Update Report (April 2024)

This report has been prepared to assess the evidence provided for the partial discharge of Condition 8 of Outline Application 14/02121/OUT amended by 22/03492/NMA and S106 Schedule 11 (Zero Carbon) from 23/02786/OBL for Phase 2 of Himley Village, which builds upon the previous Summary Report by Bioregional from October 2023. Additional information and evidence has been provided by Hydrock in the document titled Energy Strategy Addendum, dated 15 February 2024, which this Update Report assesses.

Figure 2 - Proposed EUI breakdown for the Himley Village development

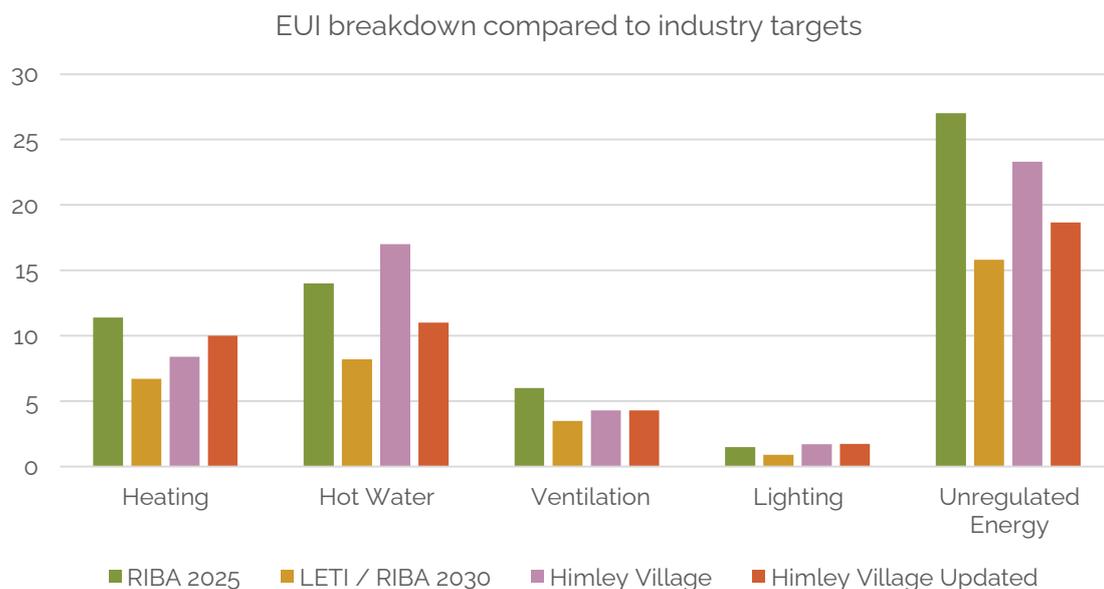
It is welcomed that a more efficient air-source-heat-pump has been selected, with a winter efficiency of 342%. As stated in the Addendum, hot water demand has significantly reduced as a result of the upgrade. However, the increased energy use for heating in Figure 2 has not been explained in the text, which is unexpected due to the increase heat pump efficiency, which should result in less energy consumption for heating purposes. **Further clarity here would be beneficial.**

A reduction in unregulated energy has been achieved from 23.3 kWh/m²/year to 18.65 kWh/m²/year through updating occupancy profiles and equipment efficiencies. It has not been made clear what these changes to occupancy profiles are and what efficiency improvements to specific appliances have been assumed to achieve the reduction in unregulated energy. **Further information and detail is required by Hydrock to clarify and evidence the significant reduction.**
